A303 Sparkford to Ilchester Dualling Scheme TR010036

8.10 Draft Statement of Common Ground with Queen Camel, West Camel and Sparkford Parish Councils

STATEMENT OF COMMON GROUND

Version	Date	Status of Version
Rev 1	January 2019	Draft for Examination Issue

Drawing Title  
**FIGURE 2.9  
LOCATIONS OF TEMPORARY WORKS AREAS REQUIRED  
DURING CONSTRUCTION - SHEET 2 OF 4**

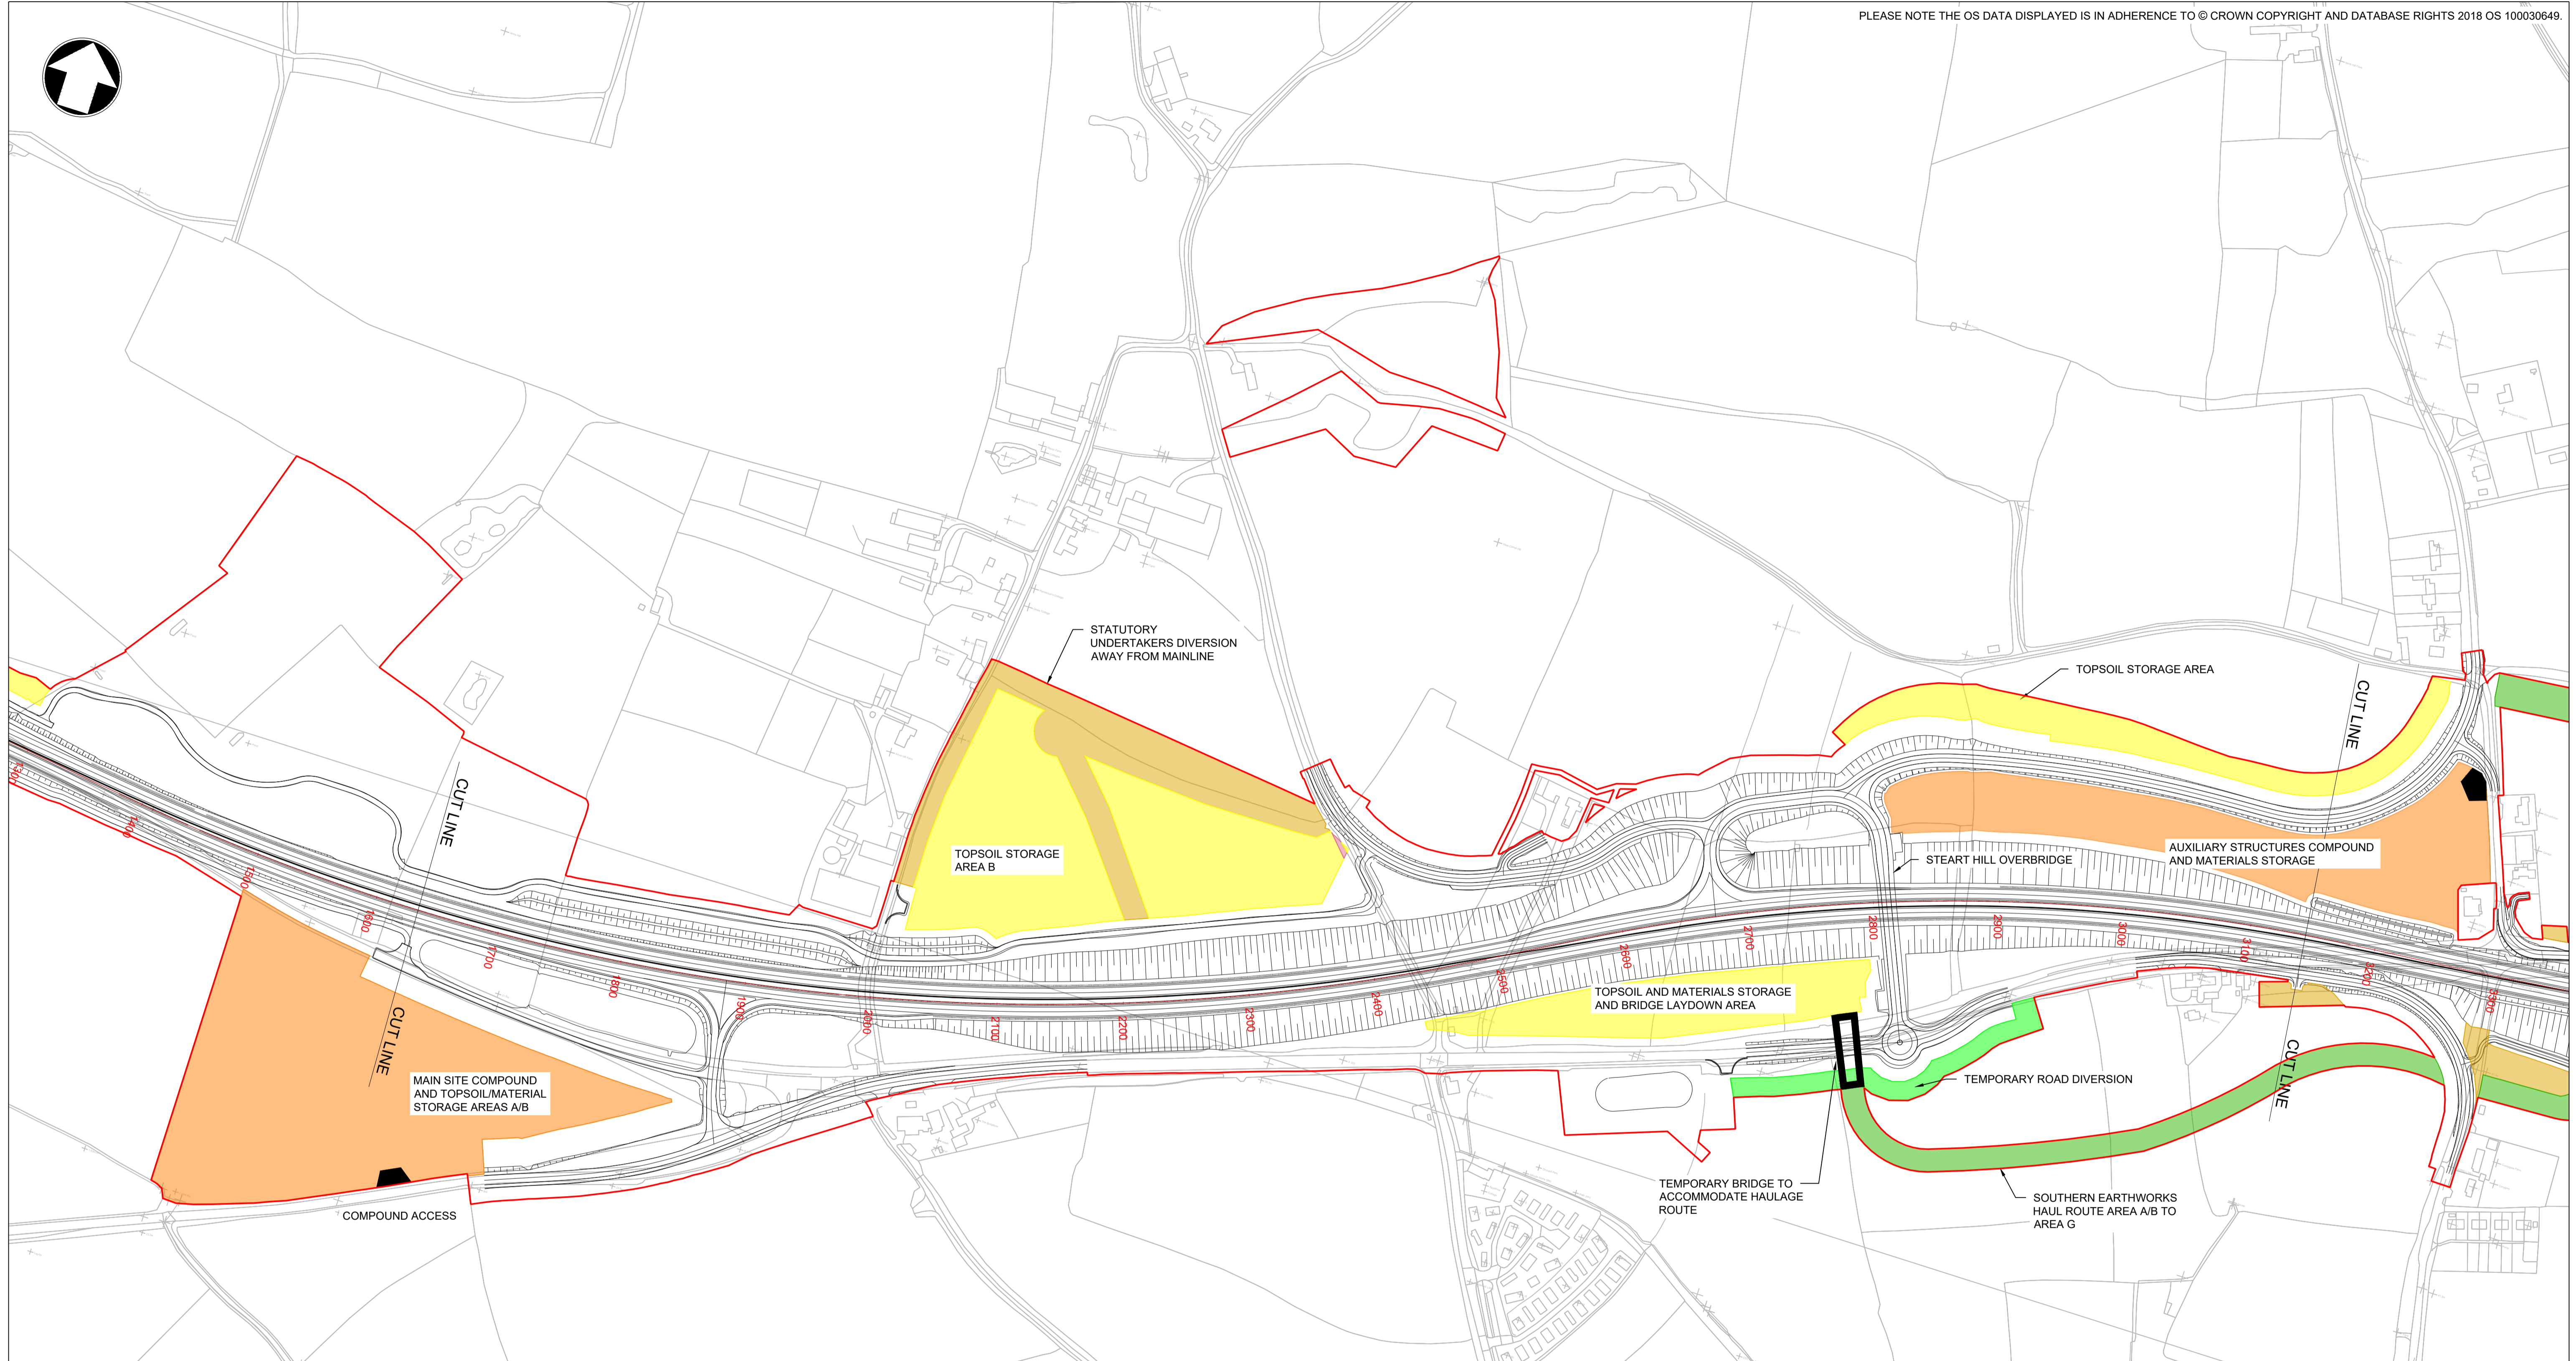
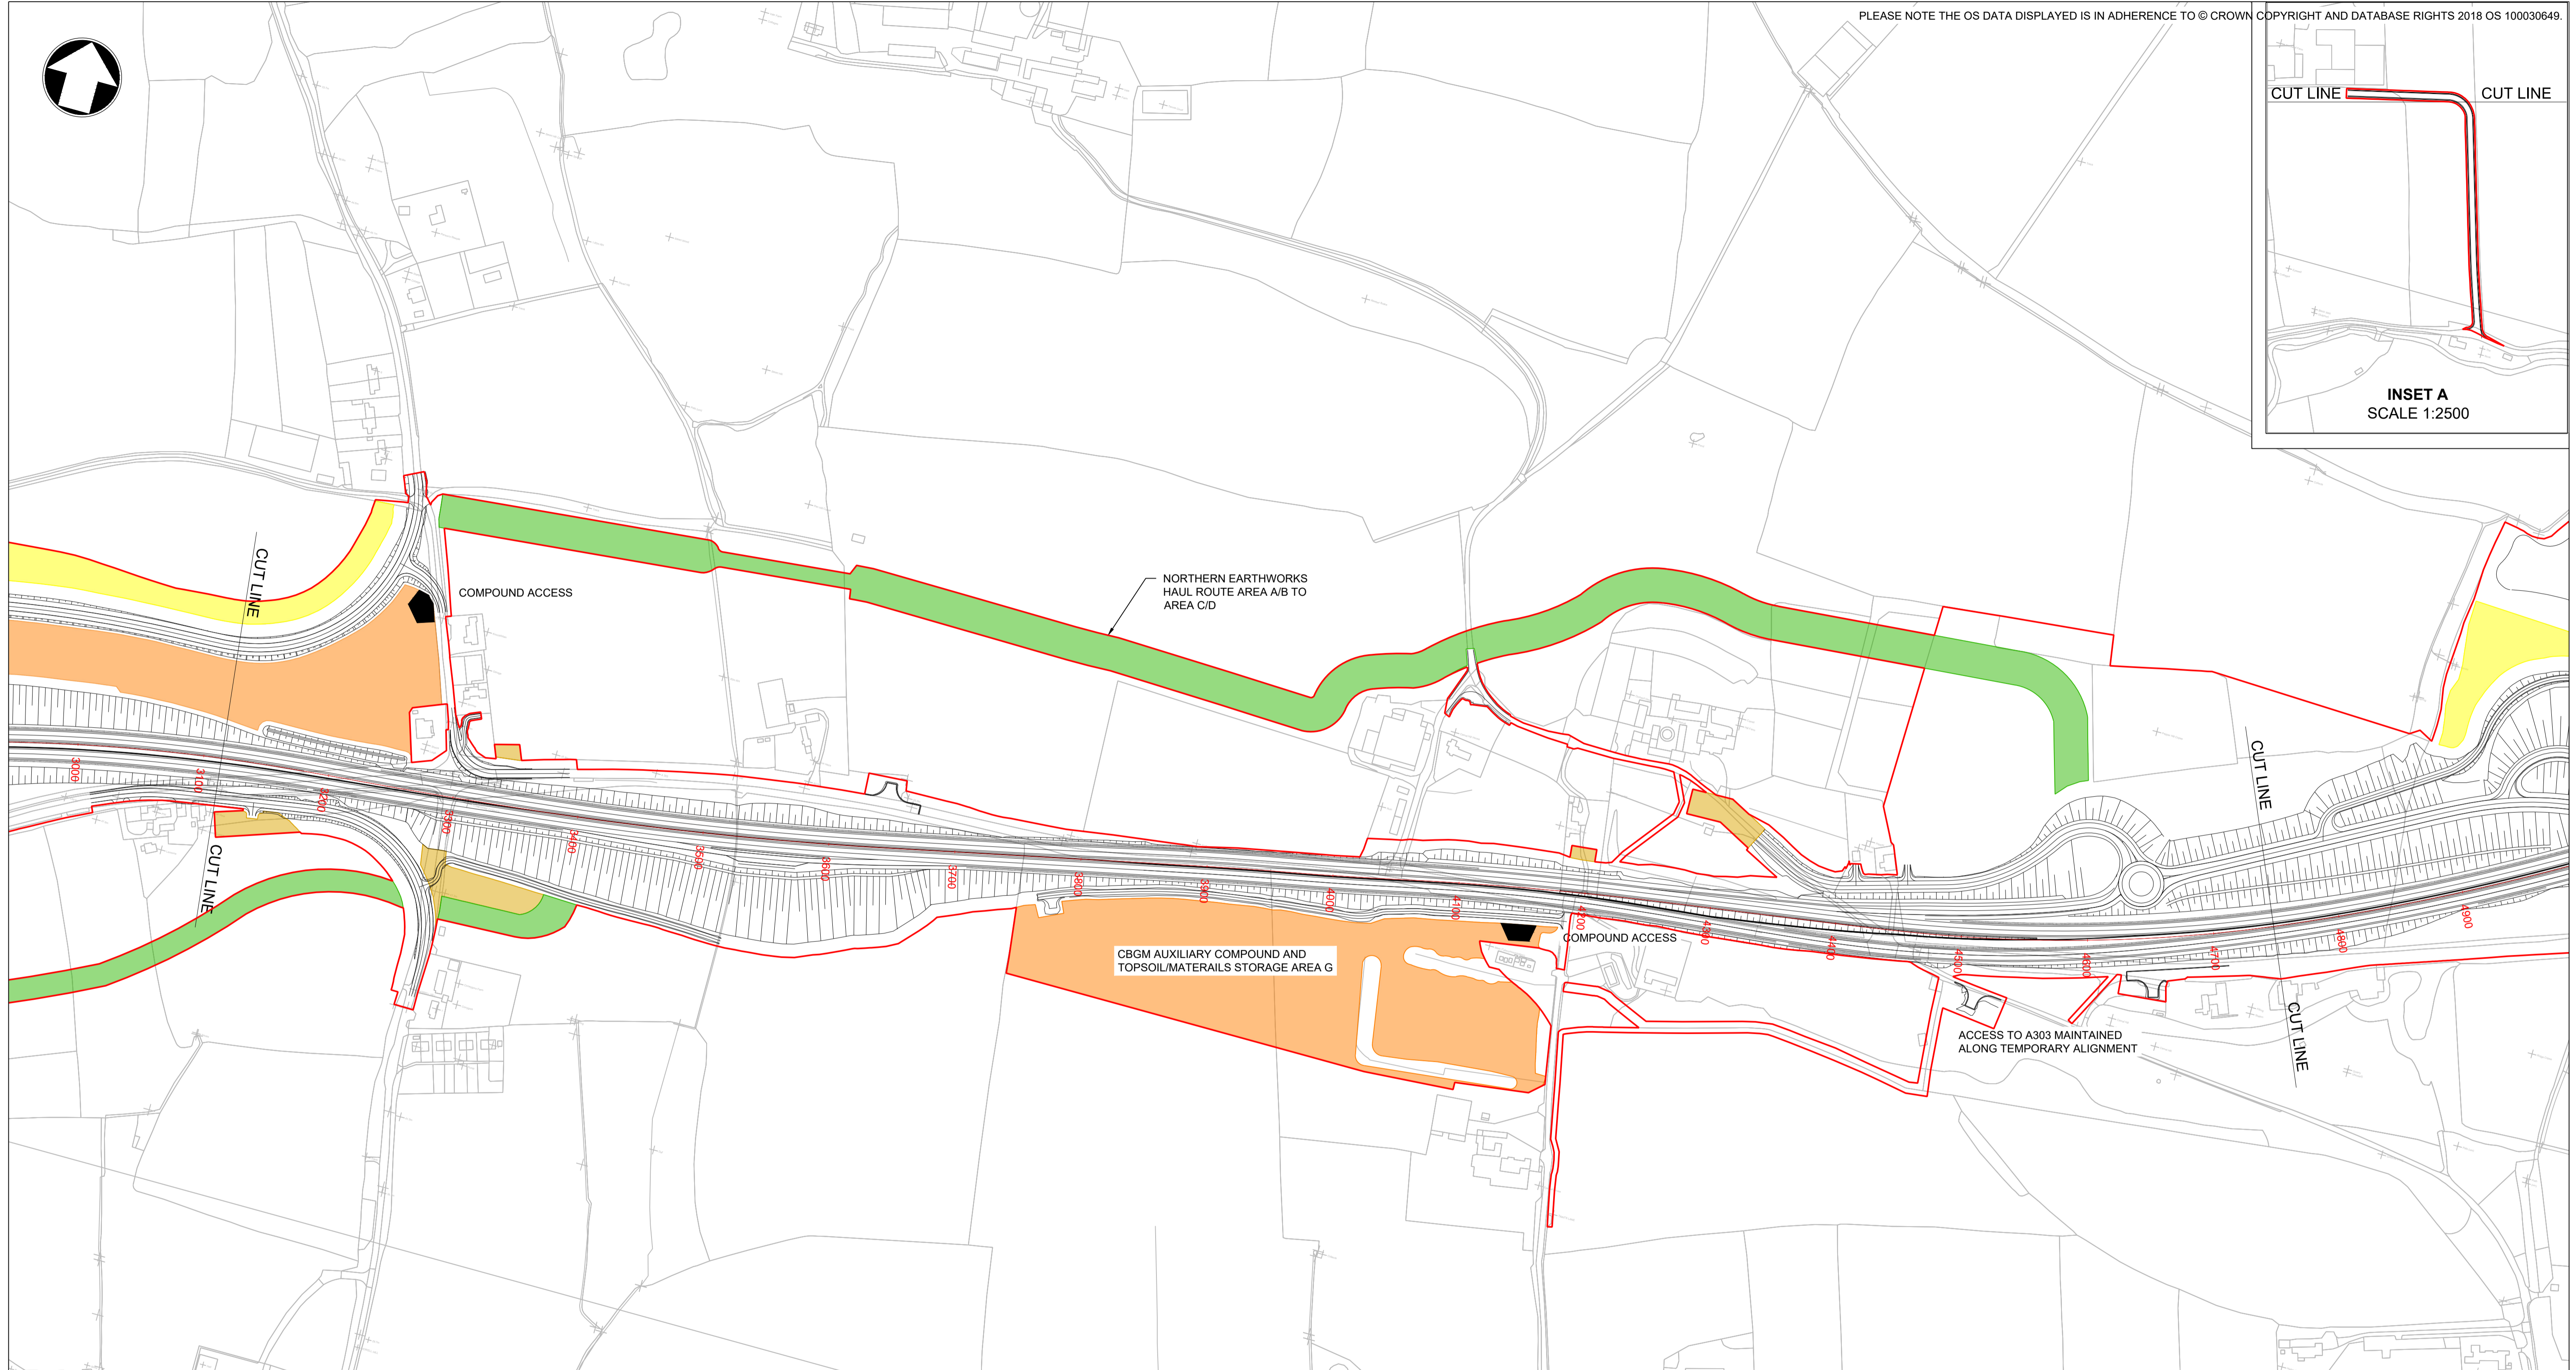
Topic	Sub-section	Comment	Highways England response	Status
	Traffic management during construction	<p>Proposed diversion via A359 - The applicant's proposed diversion of A303 traffic through Queen Camel, Marston Magna and Mudford villages into Yeovil to return via the A37 to the A303 at Ilchester are totally and utterly unacceptable to these local communities. The applicant's bland assurances that traffic will be 'managed' through a TMP do not reassure communities that suffer congestion 'rat-running' through unclassified local road each and every summer and whenever the A303 becomes congested, in either direction. Drivers will follow their SatNav devices along unclassified roads in an attempt to find a shorter diversionary route which will endanger the lives of people living in local communities.</p> <p>The Joint Councils respectfully suggest that the DCO application include details of how the applicant will mitigate the adverse impact of self-diverting traffic and further investigation be undertaken in to the provision of AMPR cameras on junctions accessing routes where HGV traffic is banned.</p> <p>We also ask that the applicant be required to mitigate traffic along A359 through High St Sparkford, Queen Camel and on the unclassified roads through West Camel.</p>	<p>The Traffic Management Plan (TMP) is being developed in consultation with Somerset County Council, and will eventually contain measures for the prevention and mitigation of the adverse impacts of self-diverting traffic. A draft of this document is provided as Appendix B5 to the Outline Environmental Management Plan (APP-148).</p> <p>It should be noted that the Development Consent Order (DCO) application also involves the temporary closure of the A303 for brief periods of time and diversion of traffic along the A359 using the diversion route that is currently agreed between Highways England and Somerset County Council. The final TMP will contain details of how the impacts of this closure will be managed.</p>	UNDER DISCUSSION

Topic	Sub-section	West Camel Parish Council comment	Highways England response	Status
	During Construction	villages. It will be vital to ensure traffic from the A303 is not diverted through the villages during the construction period.	<p>Somerset County Council, and will eventually contain measures for the prevention and mitigation of the adverse impacts of self-diverting traffic. A draft of this document is provided as Appendix B5 to the Outline Environmental Management Plan (APP-148).</p> <p>It should be noted that the Development Consent Order (DCO) application also involves the temporary closure of the A303 for brief periods of time and diversion of traffic along the A359 using the diversion route that is currently agreed between Highways England and Somerset County Council. The final TMP will contain details of how the impacts of this closure will be managed.</p>	<i>DISCUSSION</i>
